Your Ref: OWPC14680
Our Ref: BR/194/17/PL 30-06-2017
Please ask for:
Richard Temple

Demolition of the existing Foreshore office & decommissioning of existing underground toilets. New purpose built unisex toilet block including urinals, baby changing facilities & accessible WC, plus a separate beach office with public information point & first aid facilities. All located on the existing seafront promenade.

Promenade Opposite Clarence Road The Esplanade Bognor Regis

DRAWING
Proposed Toilet Elevations

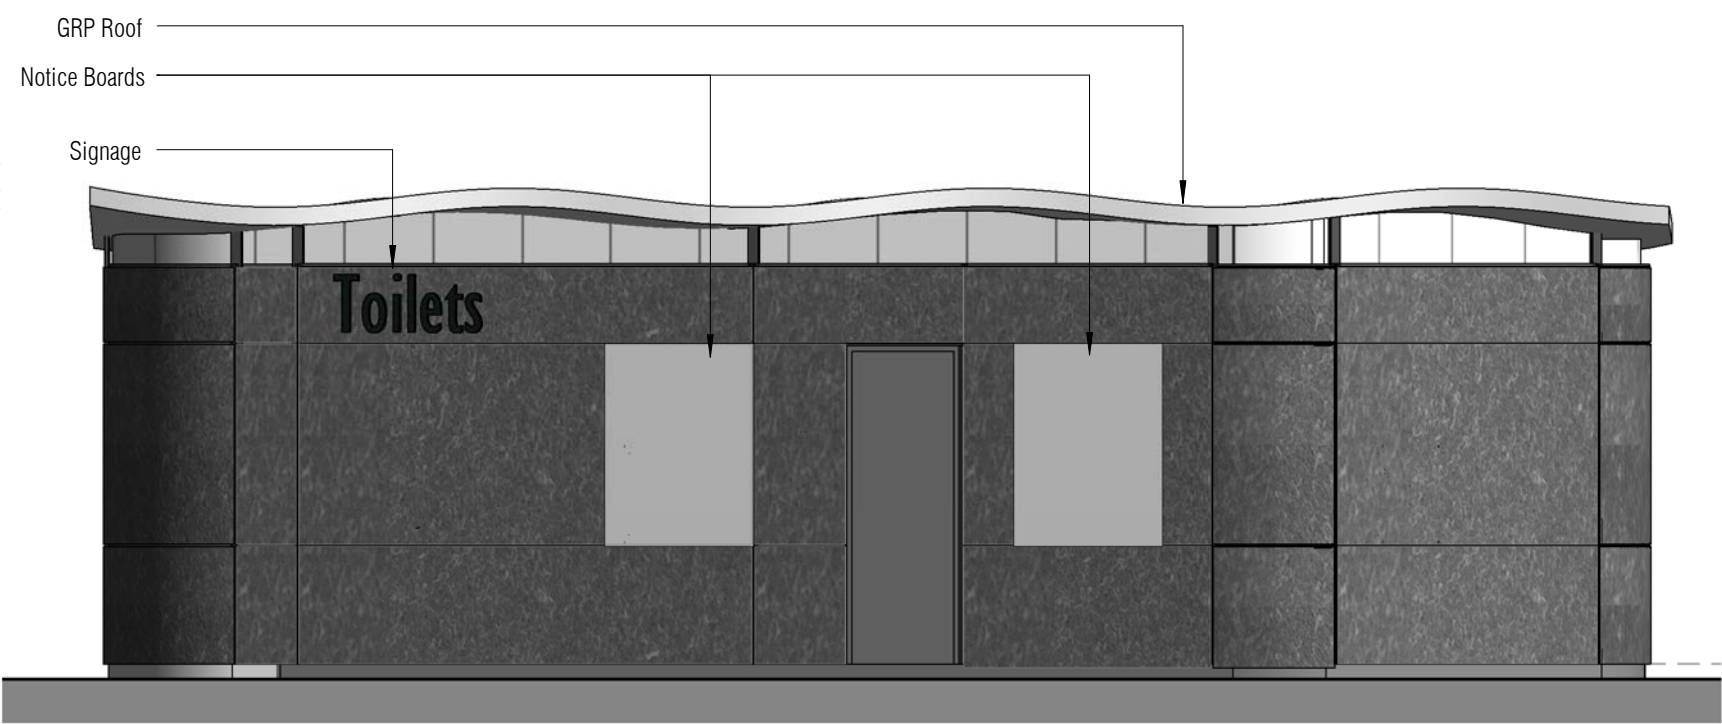
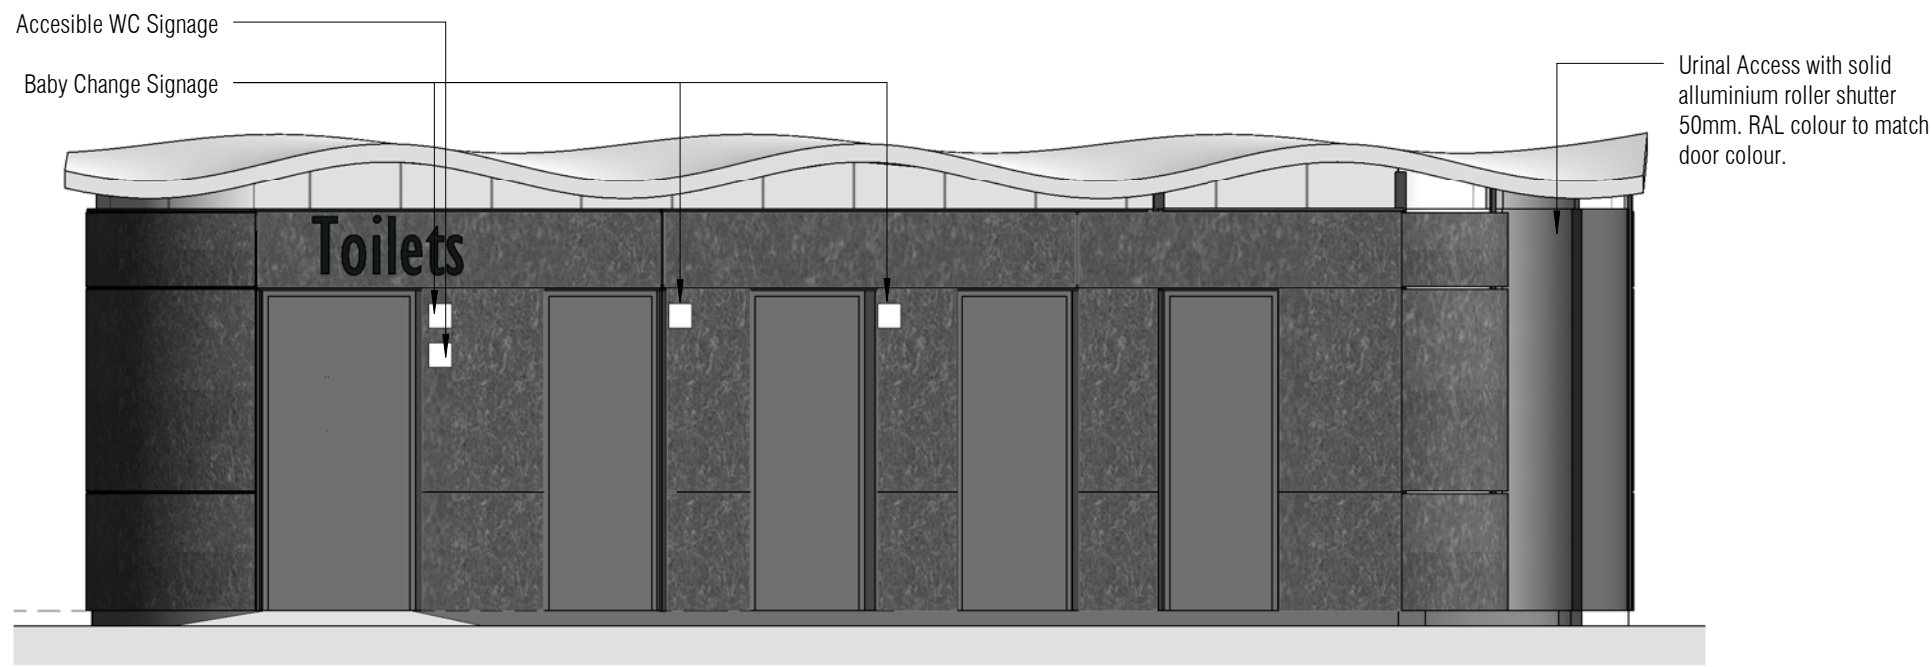
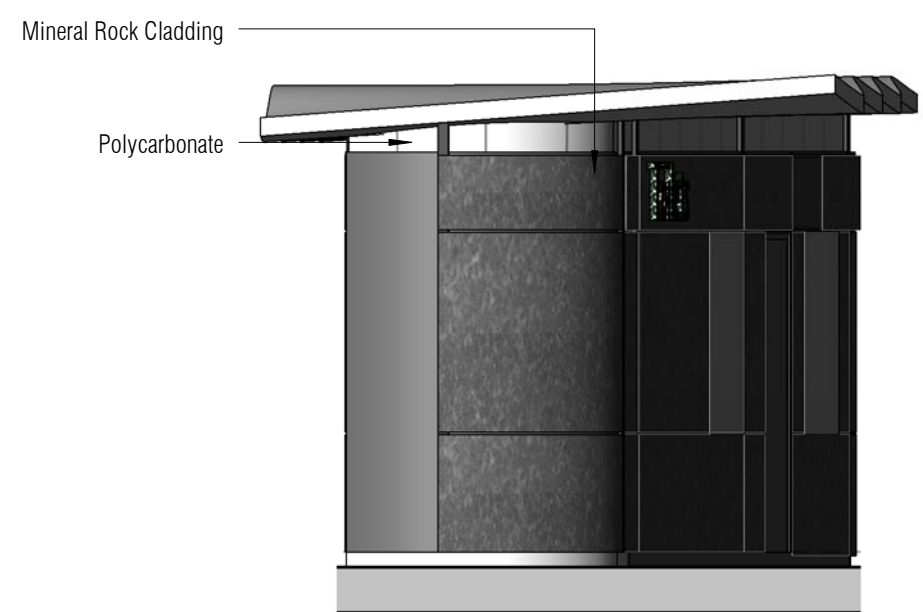
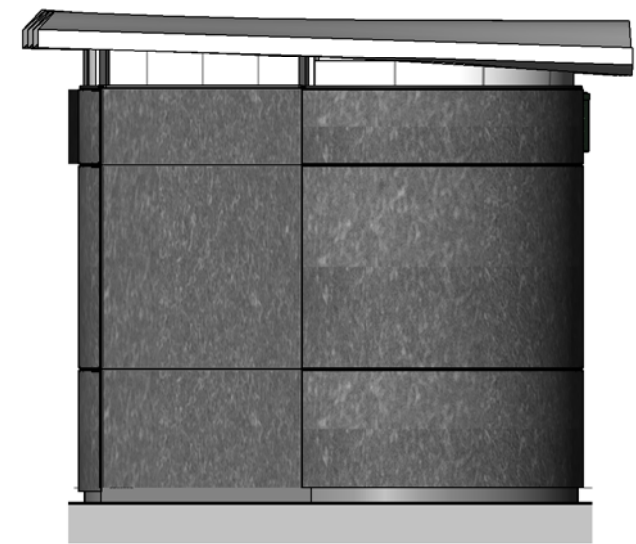
Are there any structures that would support roosting bats - no, BUT I believe the roofing structure would support the roosting of seagulls and pigeons by the very nature of its shape/ a wave.

ADC have also stated NO in relation to Breeding Birds - how can you ignore the seagulls and pigeons. Of course the current roofing structure doesn't support them but the new one looks very much like it would.

This design is very flawed, and has no consideration for the visual amenity of the area, and should be withdrawn.
